Planning and Development Services
Arun District Council
Arun Civic Centre
Maltravers Road
Littlehampton
West Sussex
BN17 5LF

Developer Services
Southern Water
Sparrowgrove House
Sparrowgrove
Otterbourne
Hampshire
SO21 2SW

PLAN-010853

Proposal: Outline applicaiton with all matters reserved for the erection of 38 No. dwellings including open space, landscaping & new access. This application is a Departure from the Development Plan.
Site: Rear of the Lillies, Yapton Road, Barnham, PO22 0AX.
BN/32/15/OUT

SOUTHERN WATER

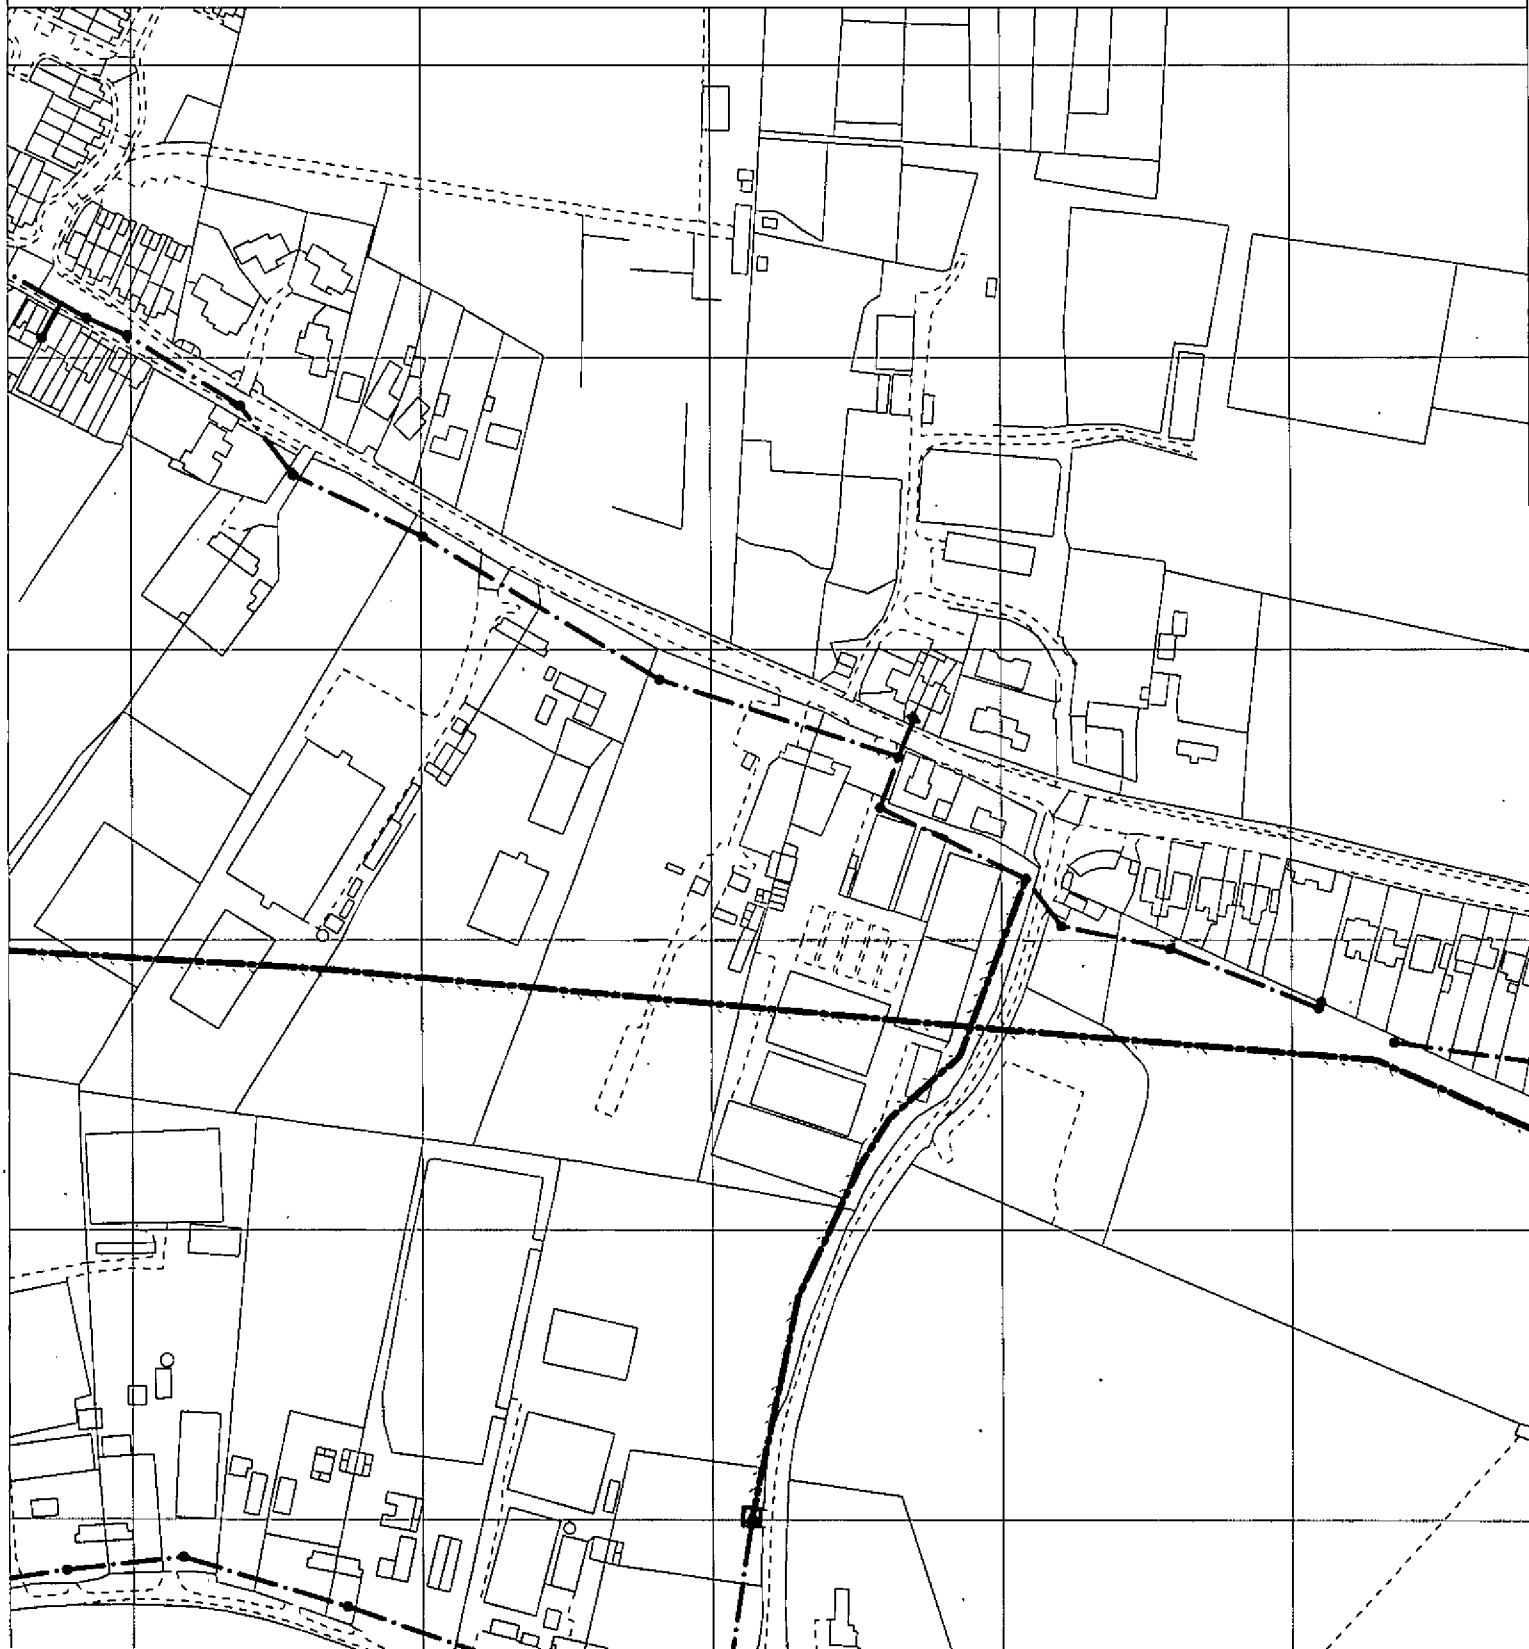
Please find attached a plan of the sewer records showing the approximate position of rising main and foul sewer crossing the site. The exact position of the rising main and foul sewer must be determined on site by the applicant before the layout of the proposed development is finalised.

- No development or new tree planting should be located within 3 metres either side of the centreline of the rising main and foul sewer.
- No new soakaways should be located within 5 metres of a public sewer.
- All existing infrastructure should be protected during the course of construction works.

In order to protect drainage apparatus, Southern Water requests that if consent is granted, a condition is attached to the planning permission. For example "The developer must advise the local authority (in consultation with Southern Water) of the measures which will be undertaken to protect the public sewers, prior to the commencement of the development."
